**CITY OF PORTLAND, MAINE
DEVELOPMENT REVIEW APPLICATION
PLANNING DEPARTMENT PROCESSING FORM
DRC Copy**

2004-0232

Lot 2 Heritage Court

Approval Conditions of DRC

## SITE PLAN LOT 2

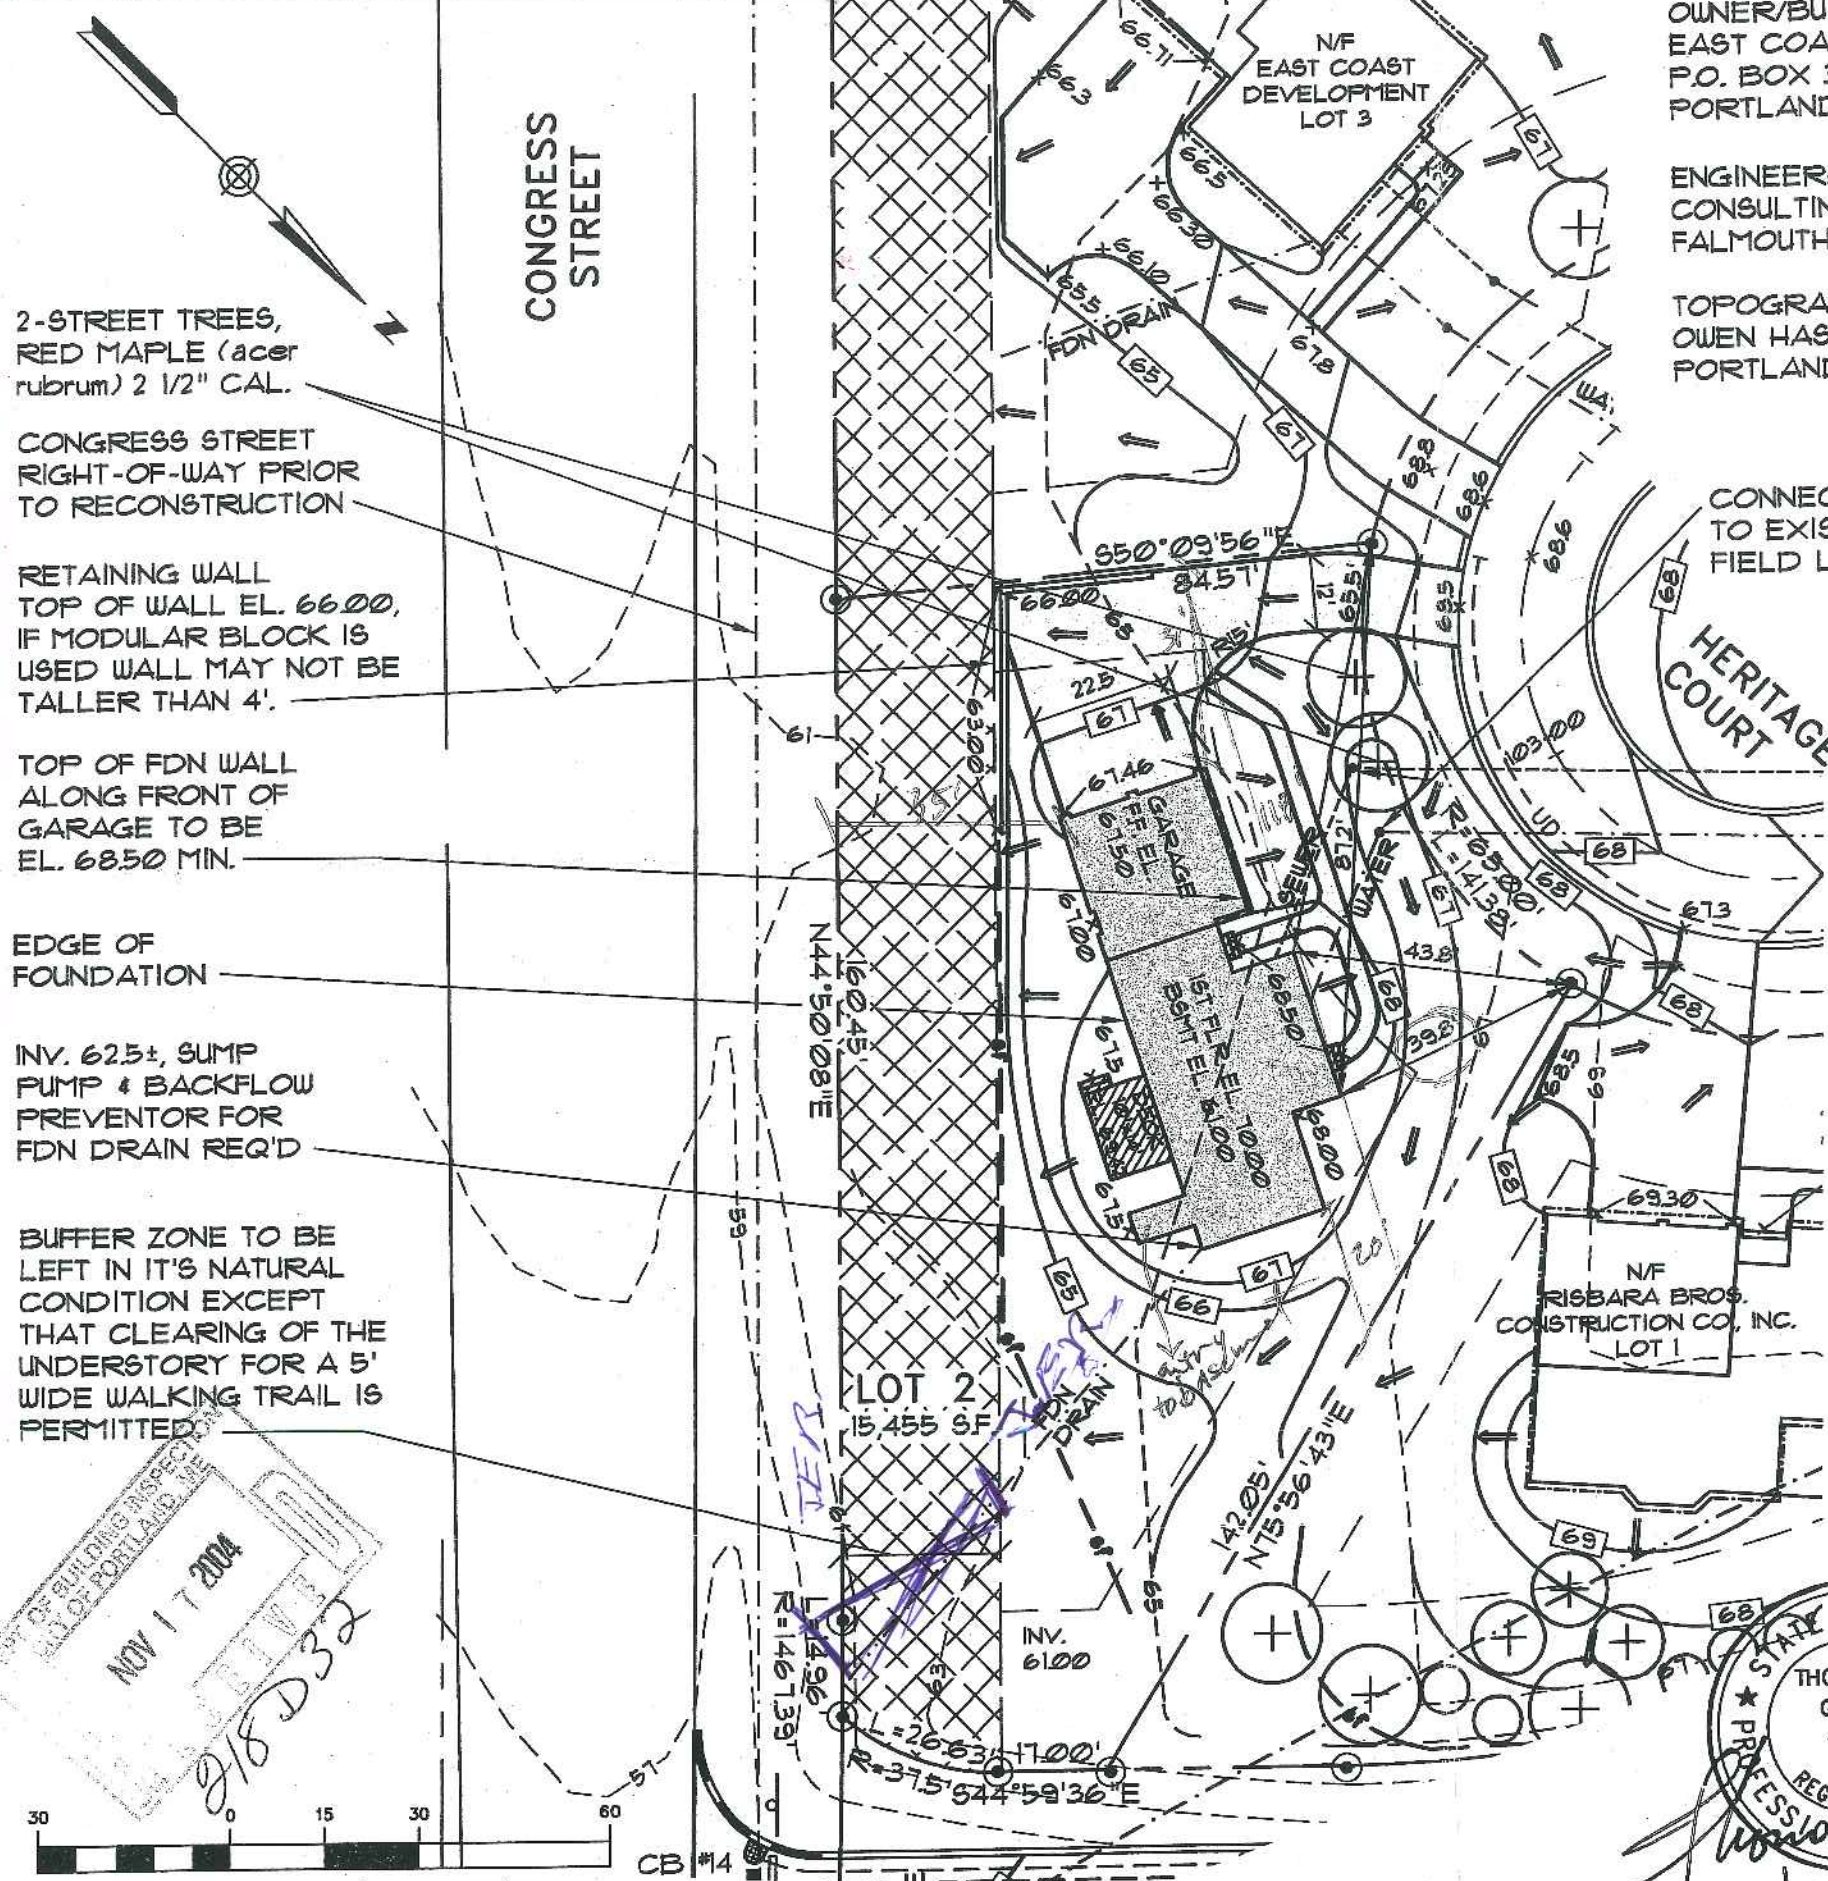
- 1 Buffer zone shall remain in its natural condition; Foundation drain shall not be installed within the existing buffer zone.
- 2 Final landscaped buffer solution to be worked out at an on-site meeting with Deb Andrews and Jay Reynolds upon completion of house construction.

- 3 All Site work (final grading, landscaping, loam and seed) must be completed prior to issuance of a certificate of occupancy.
- 4 Your new street address HAS NOT BEEN ASSIGNED TO DATE, HOWEVER, the number must be displayed on the street frontage of your house prior to issuance of a Certificate of Occupancy.

1) Add L.S. to Unincorporated Area Per HP Recommendation

2) All PD out of Unincorporated Zone

SF = 9,024.77
Sump to Sewer Not Allowed
Visit for PPE + drainage
New PL ok, merge?
